**WELWYN HATFIELD BOROUGH COUNCIL
EXECUTIVE DIRECTOR - PLANNING, PUBLIC PROTECTION AND GOVERNANCE**

DELEGATED APPLICATION

Application No: 6/2018/0371/HOUSE
Location: Stocks Lysley Place Brookmans Park Hatfield AL9 6NZ
Proposal: Erection of single storey side extension following demolition of double garage
Officer: Ms Lucy Hale

Recommendation: Granted

CLIENT	Mr & Mrs Cumberland
LOCATION/PROJECT	Stocks, Lysley Place, Brooksmans Park, Hatfield, Hertfordshire, AL9 6NZ
TITLE OF DRAWING	Proposed Ground Floor Plan & Elevations

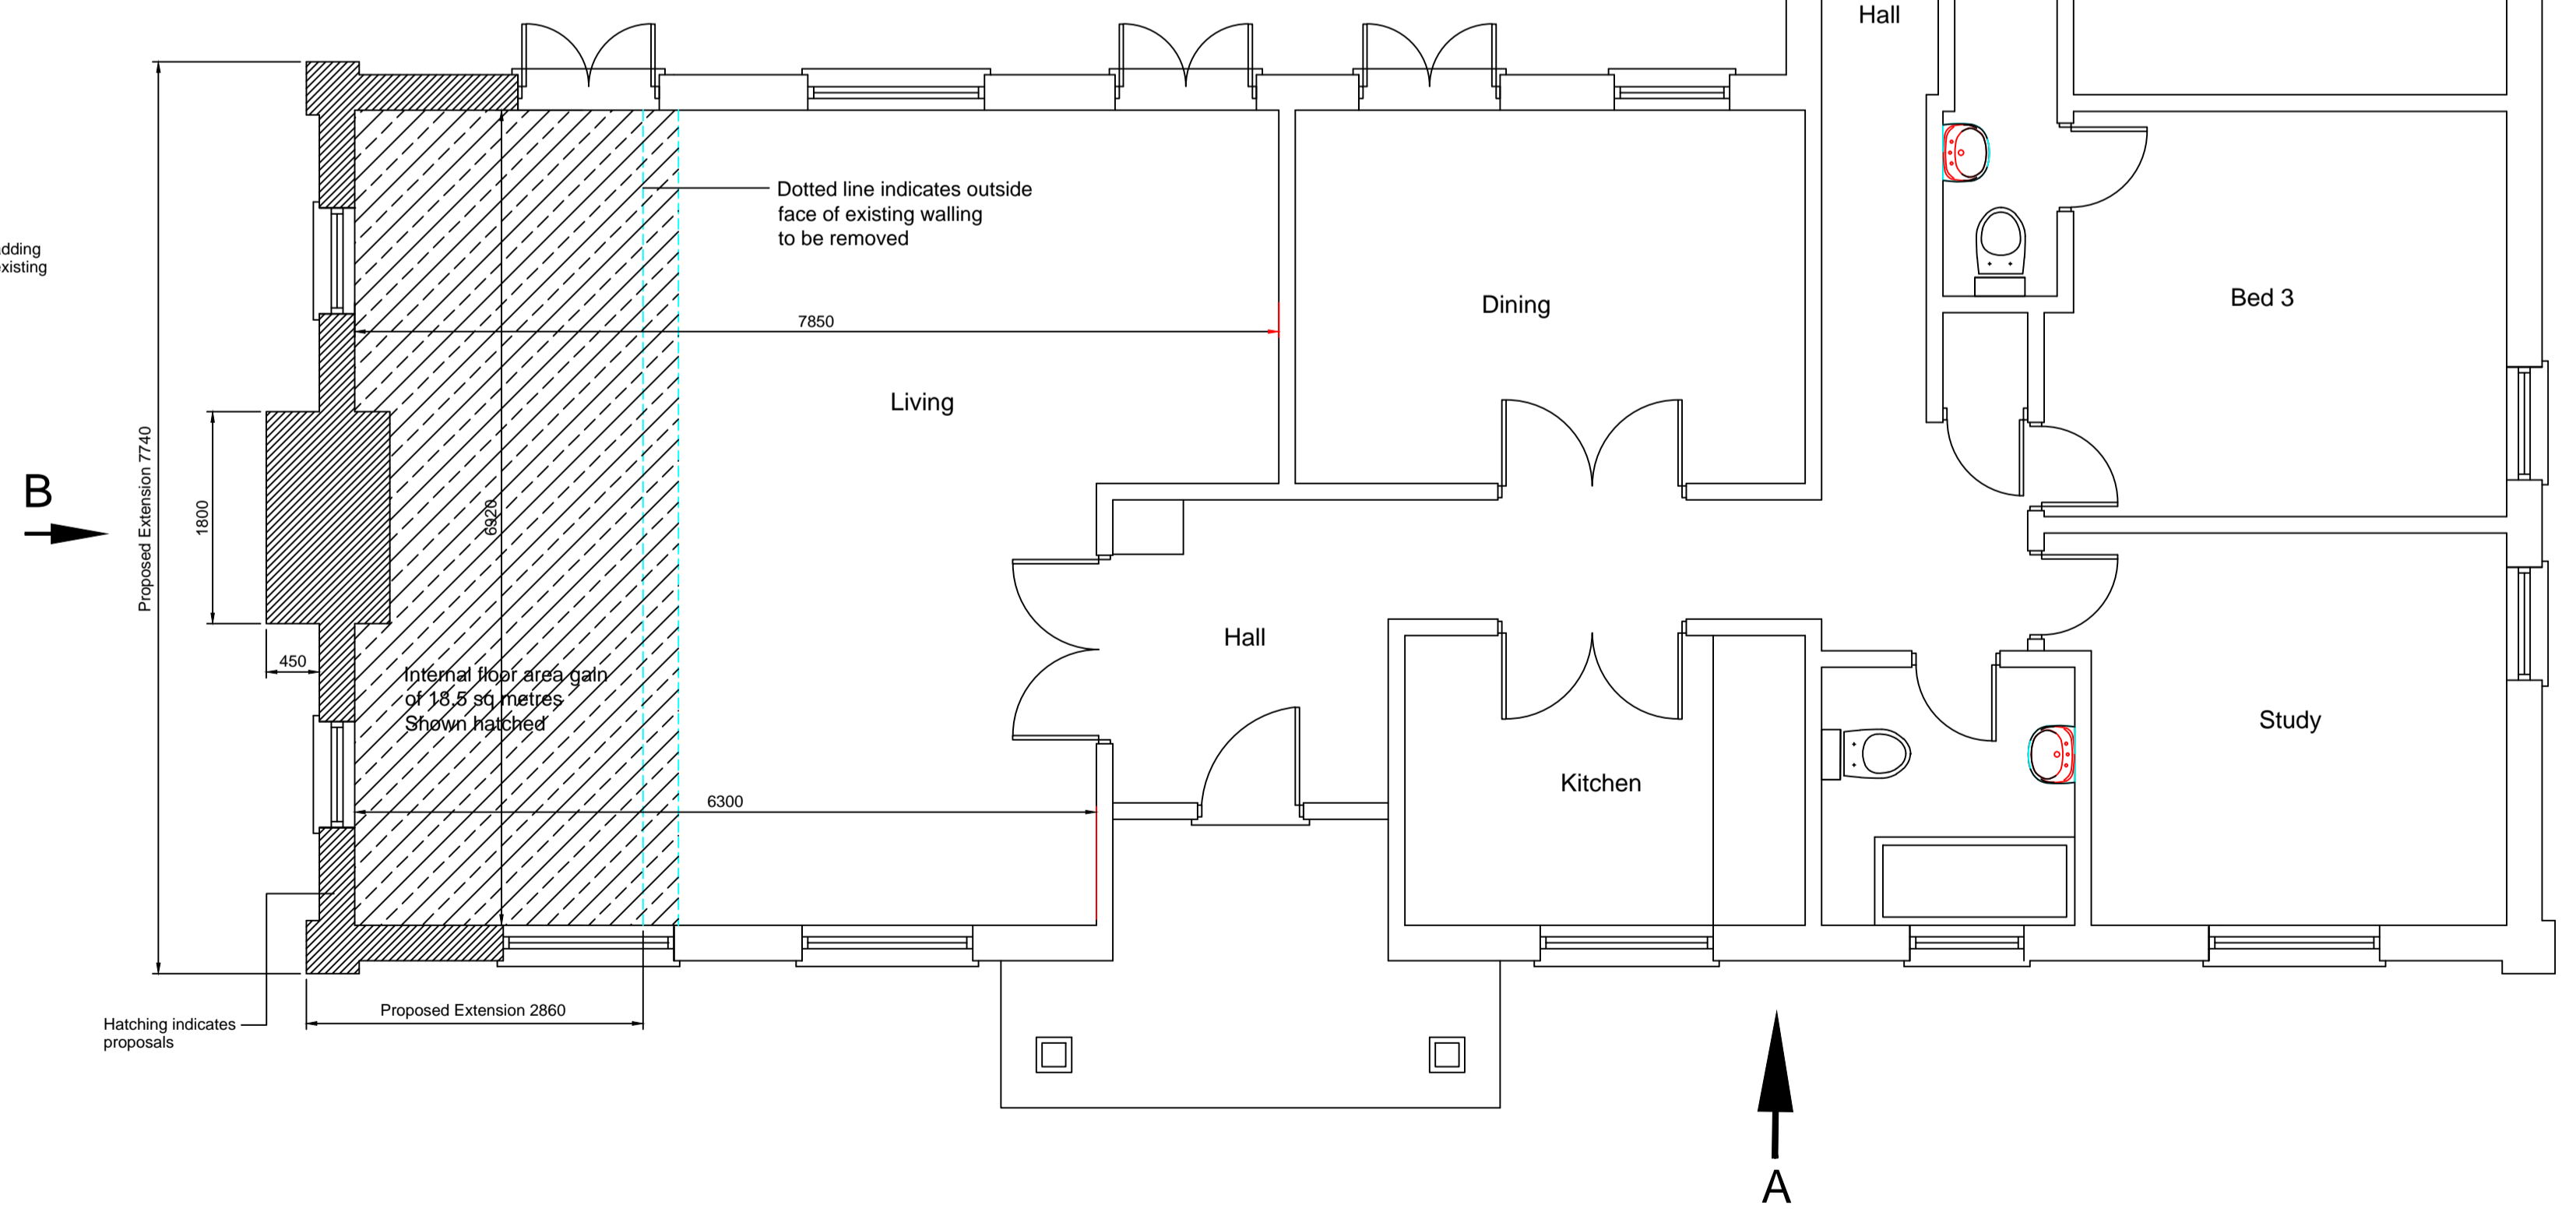
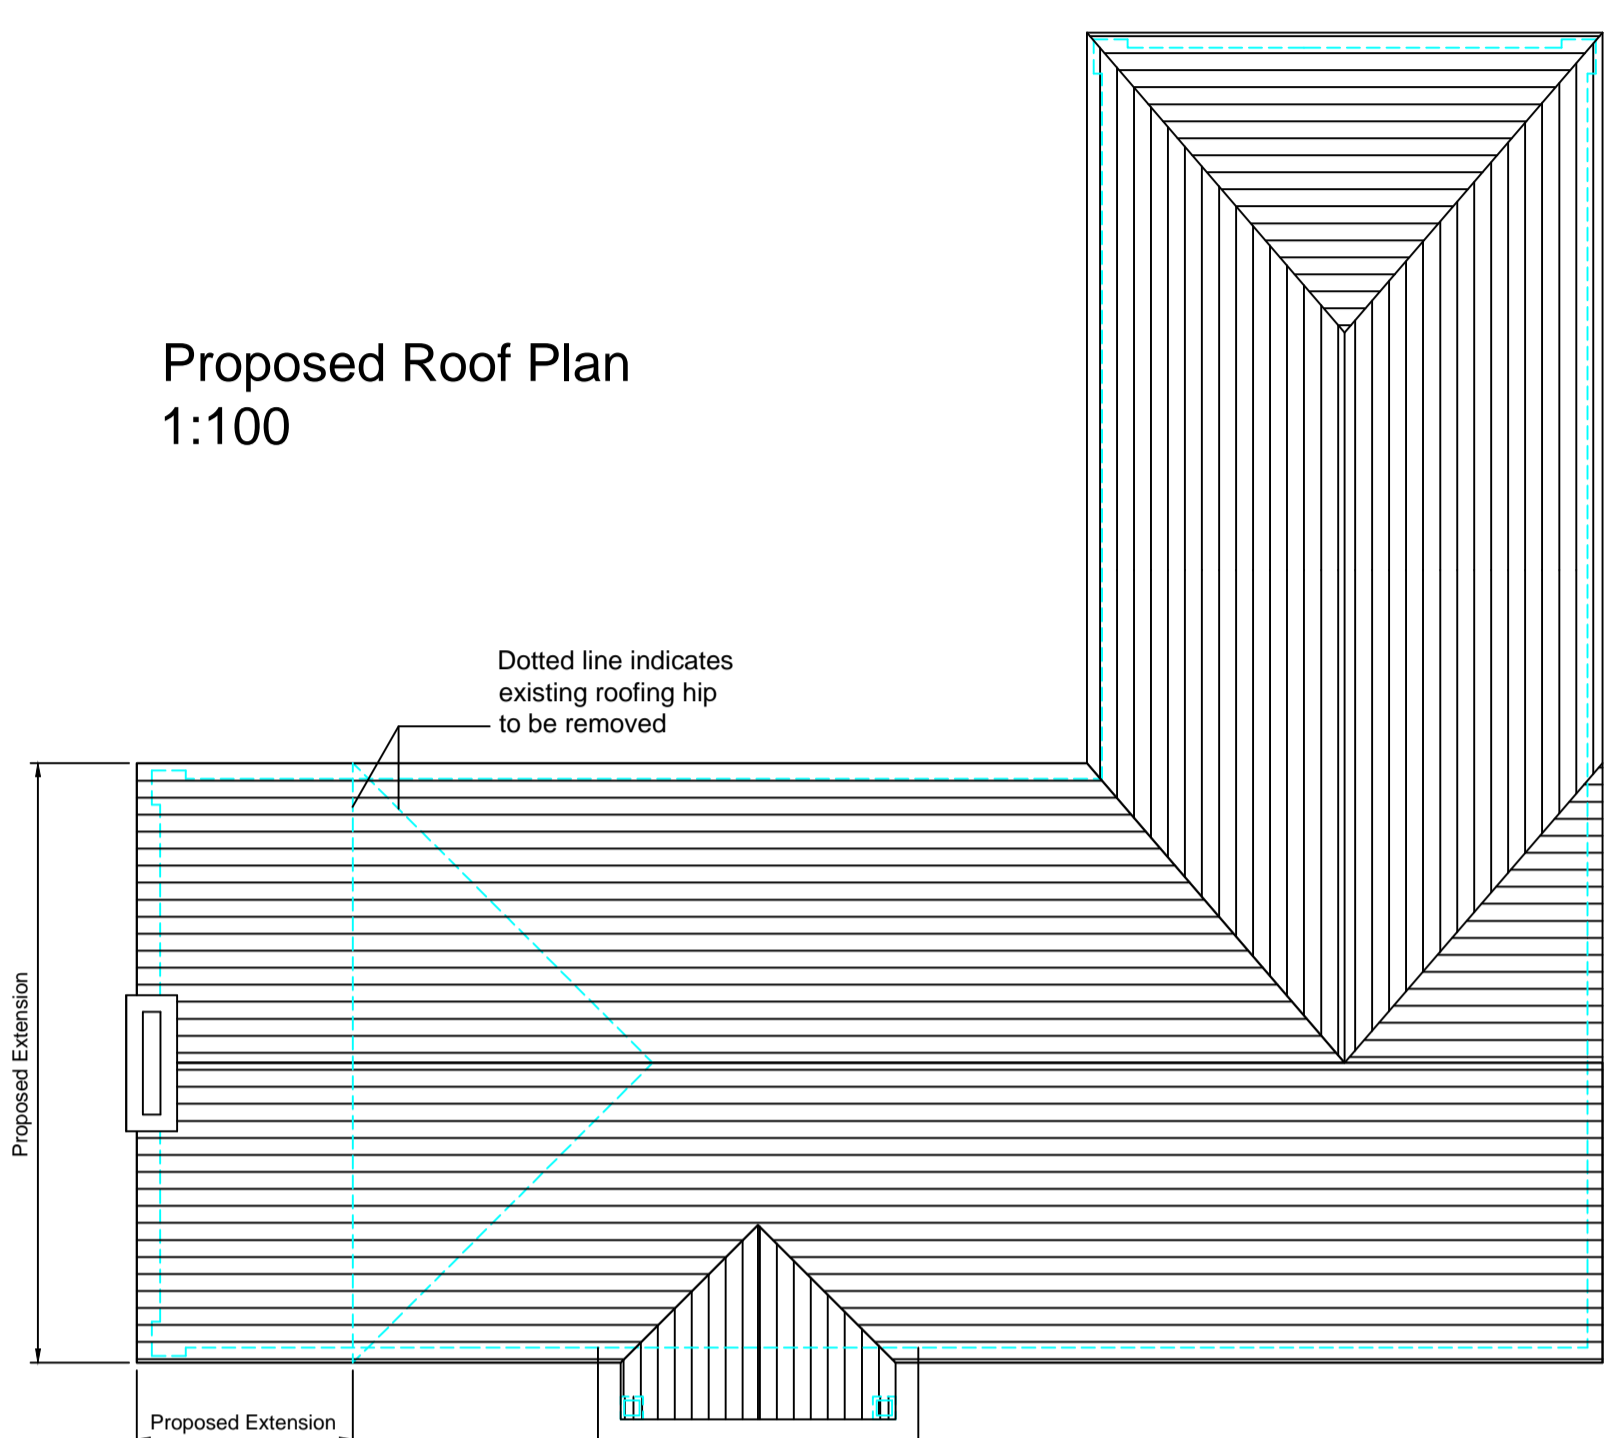
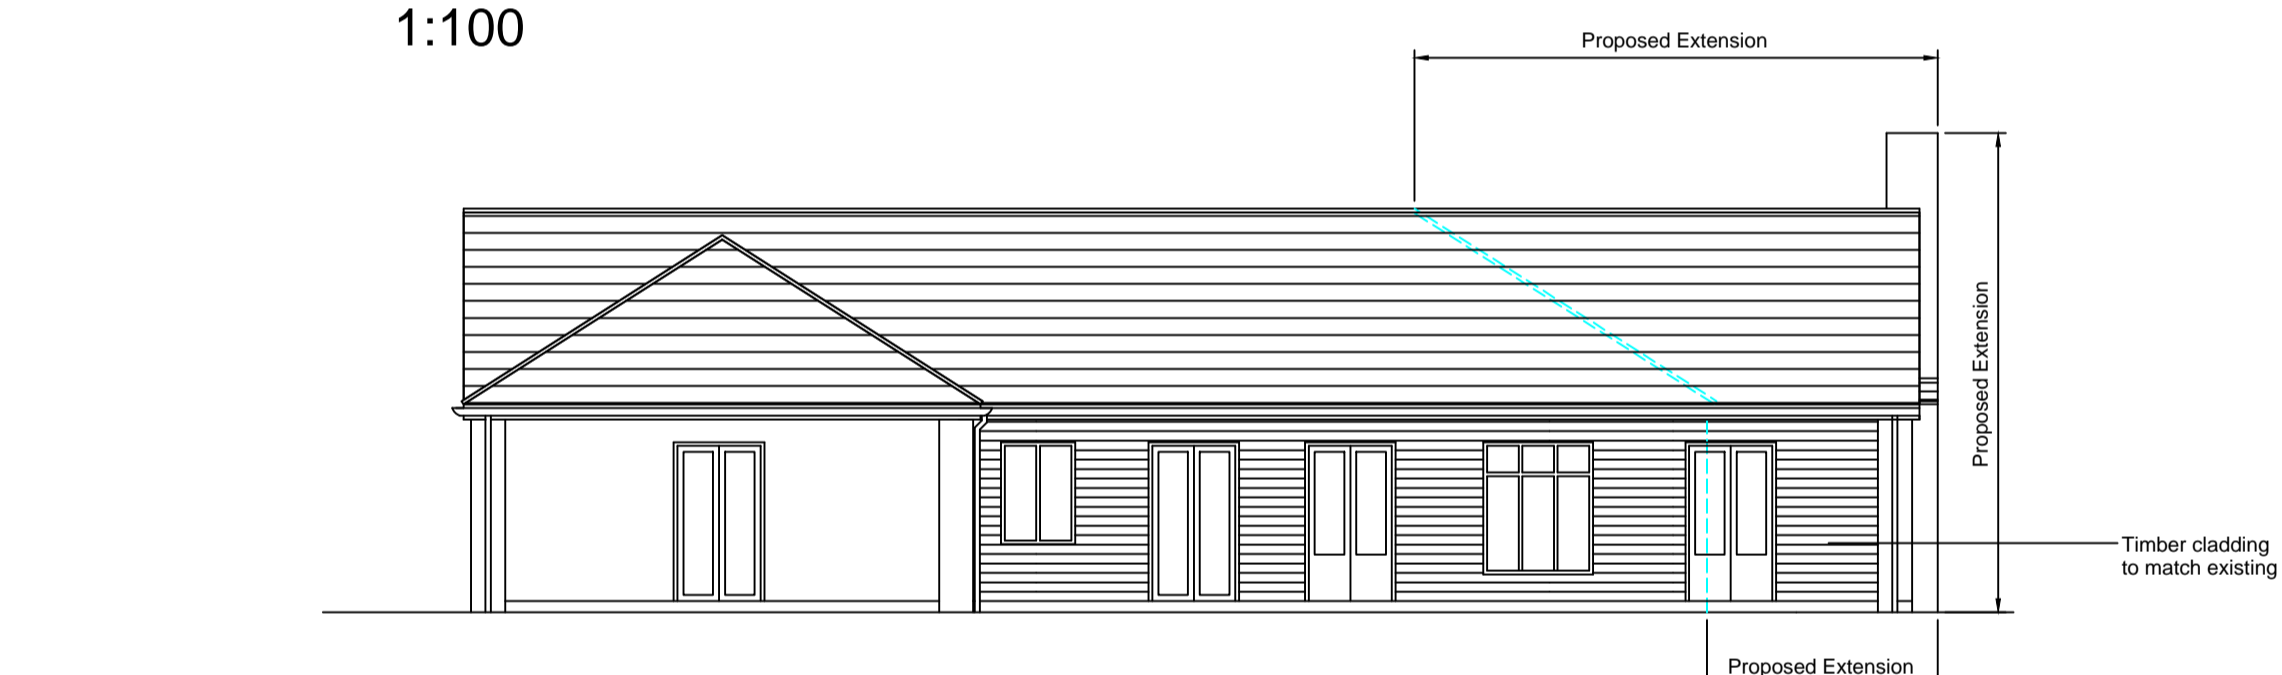
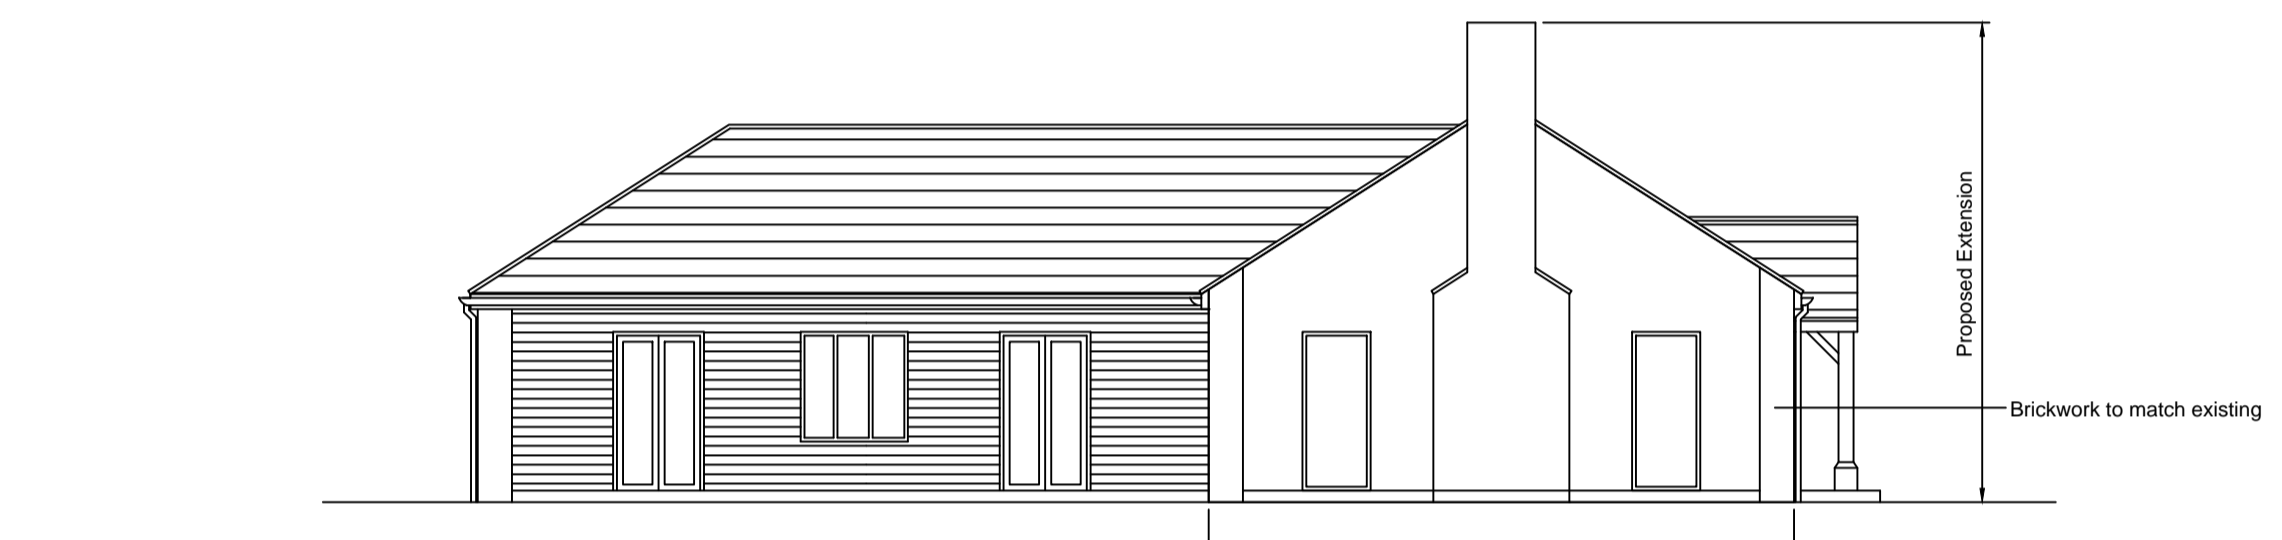
The proposed extension would have a floor area of approximately 22 sqm and the resultant dwelling would have a floor area of approximately 202.5 sqm. Therefore, the resultant increase in floor area would equate to 74.6% when compared to the original dwelling.

A quantitative assessment is not the only measure, a qualitative assessment is also taken into consideration. The extension is of single storey nature and is fairly modest in depth and width, continuing the form of the existing dwelling, however, the dwelling benefits from an existing large extension. The original dwelling was modest 3 bedroom bungalow which has already benefitted from a large rear extension, creating an 'L' shape dwelling which has already significantly increased the bulk and mass. When taking into consideration the proposed extension with the existing extension and alterations to the dwelling, these would result in a cumulative impact which would be disproportionate to the original dwelling.

In terms of the effect of the side extension on the openness of the Green Belt, the proposed increase in volume would materially increase the bulk and mass of development on the site thereby reducing the openness of the Green Belt. Whilst it is noted that the extension would not be highly visible from public

<p>vantage points, the presence of the proposed extension combined with the existing extensions of such size, would detract from the openness of the Green Belt and thereby conflict with one of its essential characteristics.</p> <p>'Very special circumstances' have been advanced, which is addressed below.</p>
<p>Design (form, size, scale, siting) and Character (appearance within the streetscene)</p>	<p>Policy RA10 states that proposals for development in the rural areas will be expected to contribute, as appropriate, to the conservation, maintenance and enhancement of the local landscape character of the area in which they are located. The application site is located within the North Mymms Common and Newgate Street Formed Plateau Landscape Character Area. The objectives of the landscape character area are to conserve and restore. Taking into consideration the size of the proposal and location of the site and its boundary treatment, it is not considered to detrimentally impact on the objectives of the North Mymms Common and Newgate Street Formed Plateau Landscape Character Area which complies with Policy RA10 of the Welwyn Hatfield District Plan 2005.</p> <p>Policies D1 and D2 of the Welwyn Hatfield District Plan 2005 respectively require high quality design in all new development and for proposals to respect and relate to the character and context of their location. These policies are expanded upon in the Council's Supplementary Design Guidance (SDG) which requires that residential extensions should be complementary in design and be subordinate in size and scale to the existing dwelling.</p> <p>The extension would continue the form and ridge height of the existing dwelling and is considered to appear subordinate in scale. The architectural style, windows, detailing and materials are appropriate to the original dwelling in accordance with Policies D1 and D2 of the Welwyn Hatfield District Plan 2005 and SDG 2005.</p>
